CITY OF ALBUQUERQUE

PLANNING DEPARTMENT – Development Review Services

RE: **Paradise RV Park Phase 1 (File: K08D003)**
Drainage Report, Engineer's Stamp Date 1-23-2015
Grading and Drainage Plan, Engineer's Date 1-23-2015

Basin Map

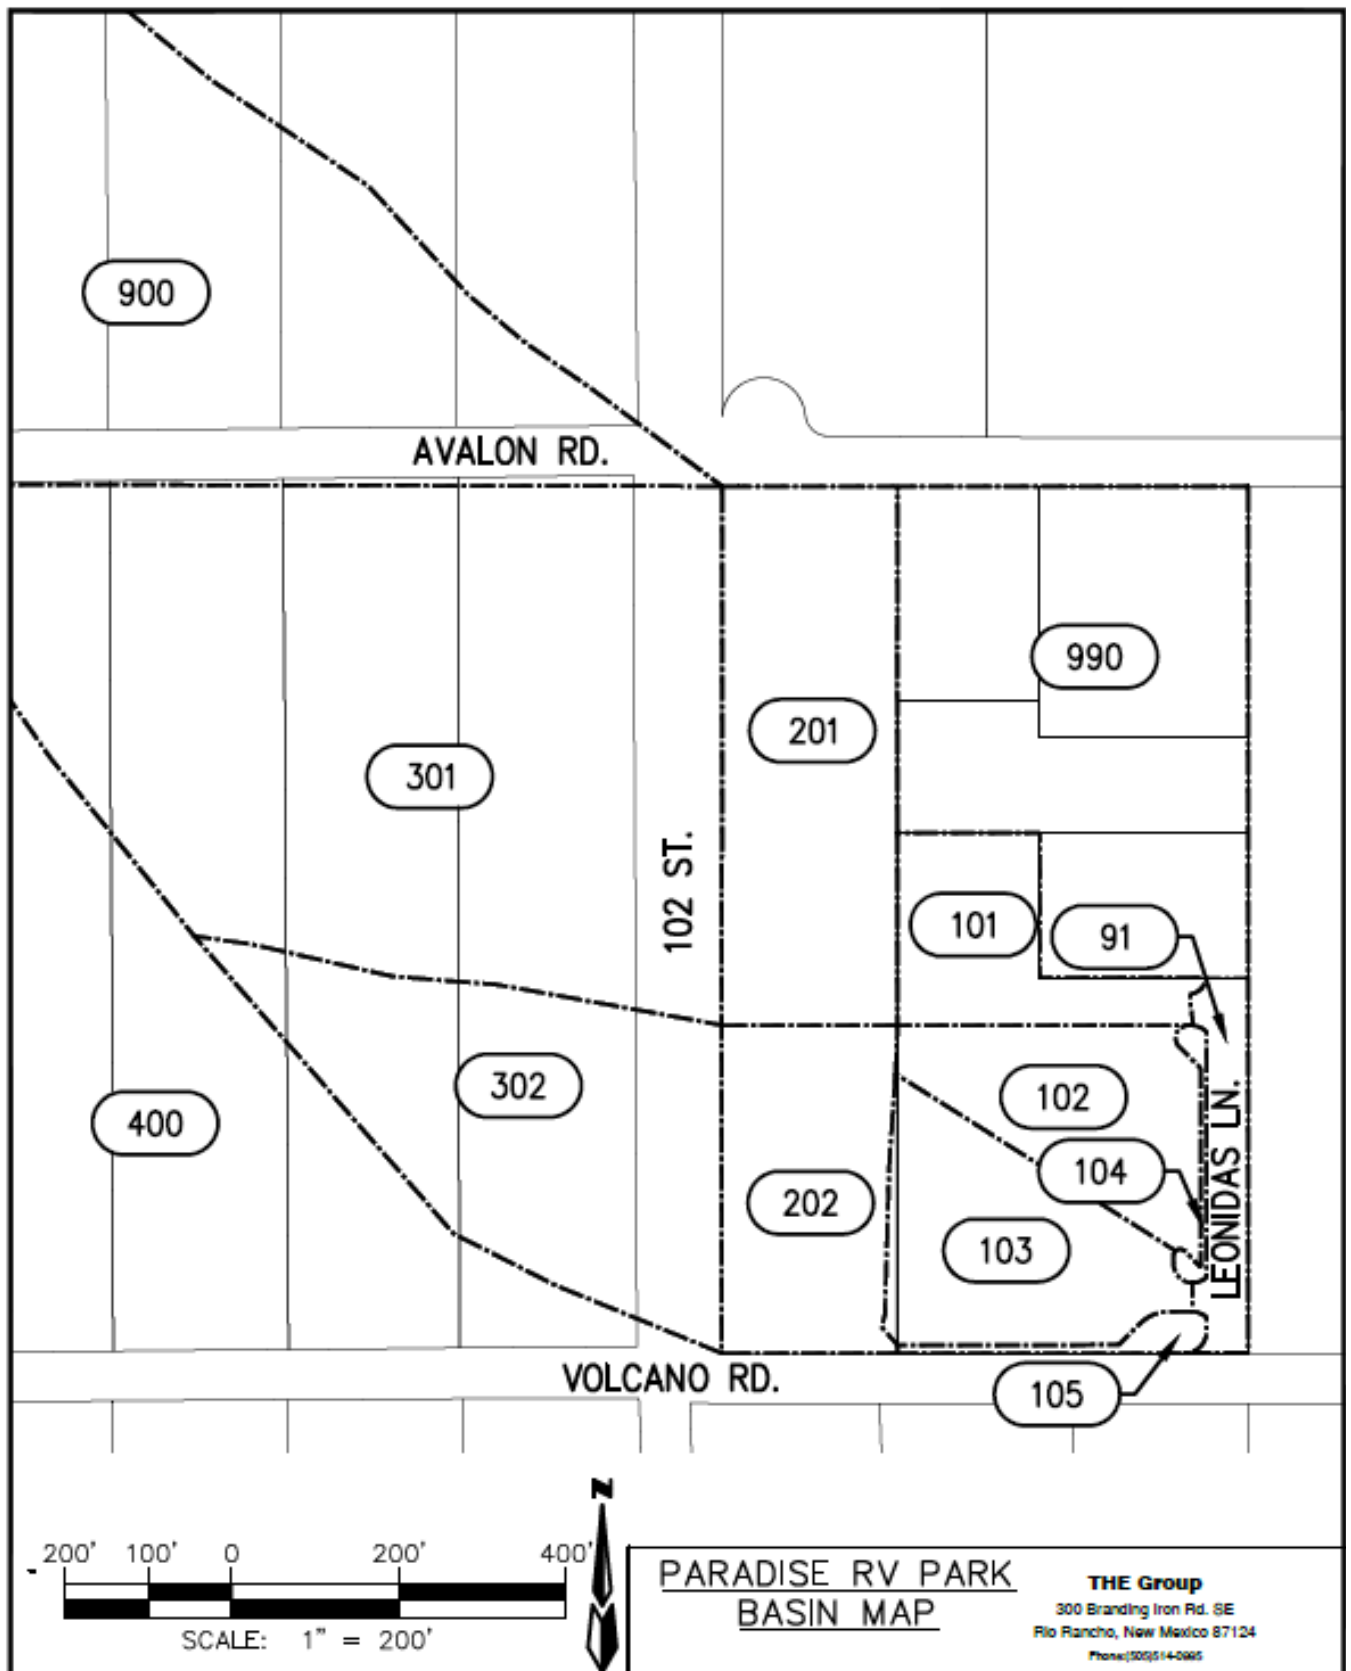
- This report separates Basin 300 into 2 basins. Indicate why.
- In the L.Read report, the pond on Phase II site retains runoff from undeveloped (A = 100%) Basins 200, 300, 800, and 900. Though in the developed condition Basin 800 is intended to go down 106th St.

- Per the L.Read report, up to the SW corner of site the developed flows of Basins 300 to 900 were calculated to be 678.74 cfs. **This does not include developed Basin 200 and needs to be included.** Basins 300 thru 900 are based on developed Land Treatments B=3, C=30, and D=67%. Summarize this information in the storm drain analysis.

- At stated above, flows from Developed Basin 200 (201 and 202) need to be added to developed flows into SD in Volcano. Land treatments should be similar to those used in Basin 100 (101 thru 105). The L. Read report calculated 17.57 from Basin 200, but this is

too low since it is based on B,C, D = 5, 76, 19 respectively. The SD schematic shows 737 cfs. Determine the correct flow. I'm estimating about 25 cfs from developed Basin 200.

Storm Drain Layout

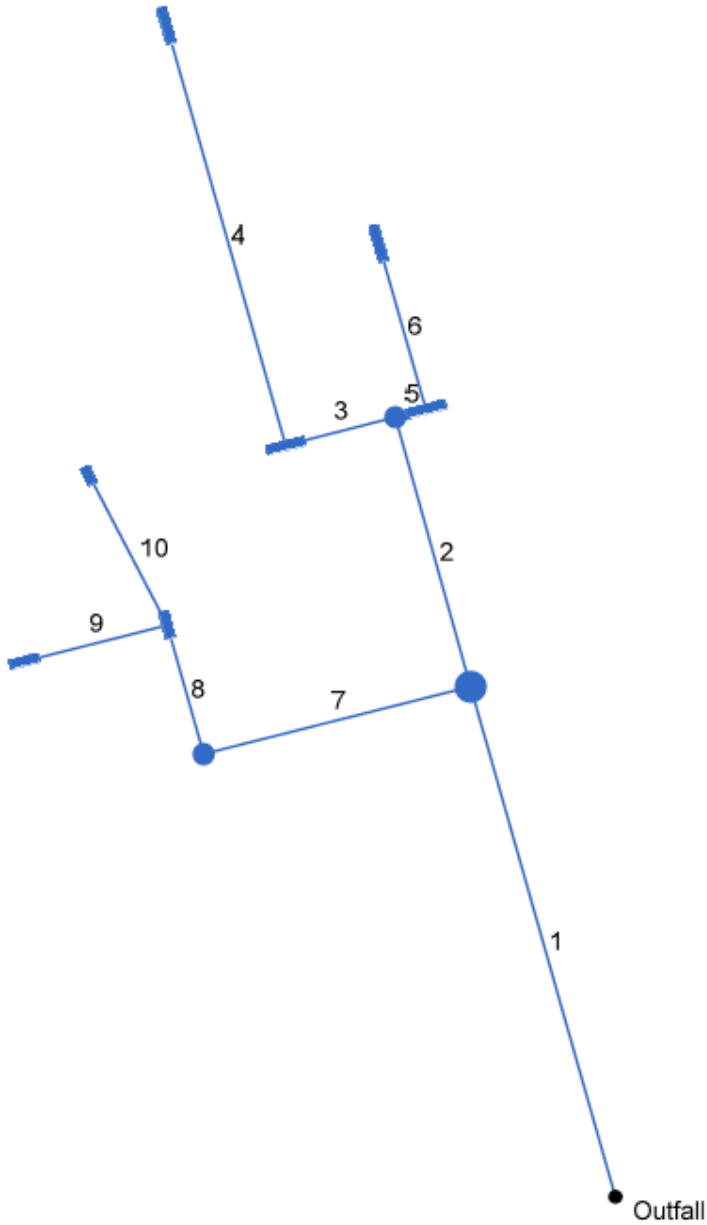
- Was street flow from Volcano Road included in the 737cfs value?
- The same schematic mentioned above shows a 96" dia SD beyond the 72" SD. Review the hydraulic calculations and verify the validity or modify if needed.
- The outfall into the pond shows two pipe penetrations into the Dam. This may require approval by the state engineer. Inquiries to DMD will be made, and the determination on this will be forthcoming.

- The Q in the 24" SD in Leonidas Lane of 27.9 cfs does not match the combined basins flow of 29.07 cfs (update value)

- Report states that capacity is based on Street Capacity. Half street capacity is 53.5 cfs (107cfs/2) but Hydraflow uses 23.98 cfs based on capacity of inlets, and bypasses 11.9 cfs.

- So that there are not bypass flows, base the street flow on the capacity of the inlets rather than the street capacity, and determine the length of road that that capacity supports. Future inlets will have to be installed at the beginning of that length. Determine if that length goes beyond the property line. If not, more upstream inlets will be required.

- The 36" SD should be based on flows from inlets on **both** sides of the developed road.
- The Type D inlet should be based on an orifice area of 3.84 SF.

FIRM MAP NO. 35001C0328H

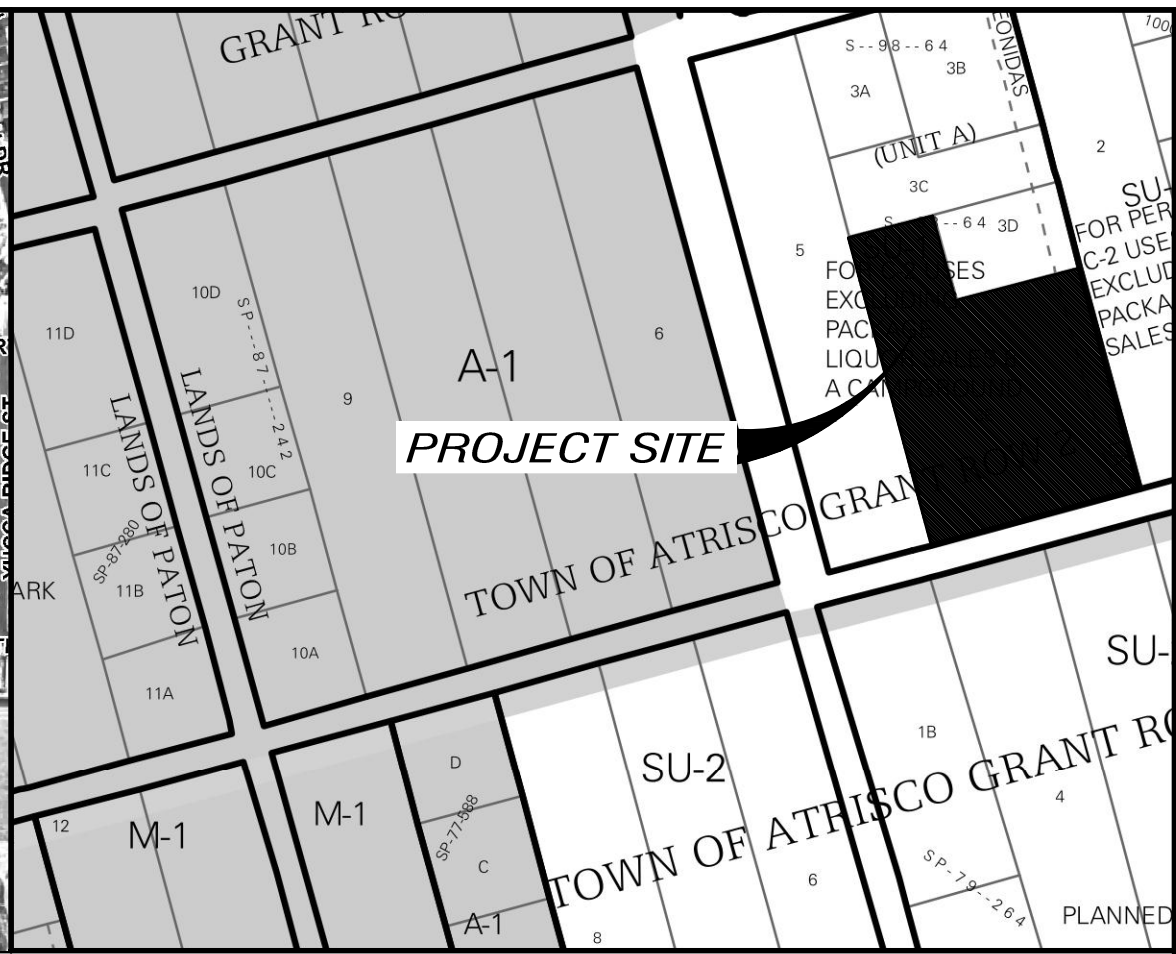
- Collect the "first flush" from the impervious area (building and paved parking). There appears to be opportunity at north side of access drive to building, within the curbed islands, and on south side (where Basin 104 label is shown).

- The pond volume must be based on the 100Yr -10day storm, not the 24 hr storm. Pond Data need not include 2x100 yr storm.
- Indicate with crosshatching the extents of the gravel area, and that of the paved area.

- Label street names
- Q values shown on the plan do not match those shown on the "Hydrologic Data" table on same sheet (update). On same table correct the land treatments shown for Basin 990

- At NW corner of site, near Play area, attempt to better direct offsite flows south by grading. Previous plan used a berm.
- Call out the retaining wall on western boundary at building. South of the pool there is a 2' grade difference. A berm may increase the length of wall needed.

- Provide calculations showing 30" culvert to pond is sufficient to divert offsite flows to pond. Top of Pipe appears to be higher than road.
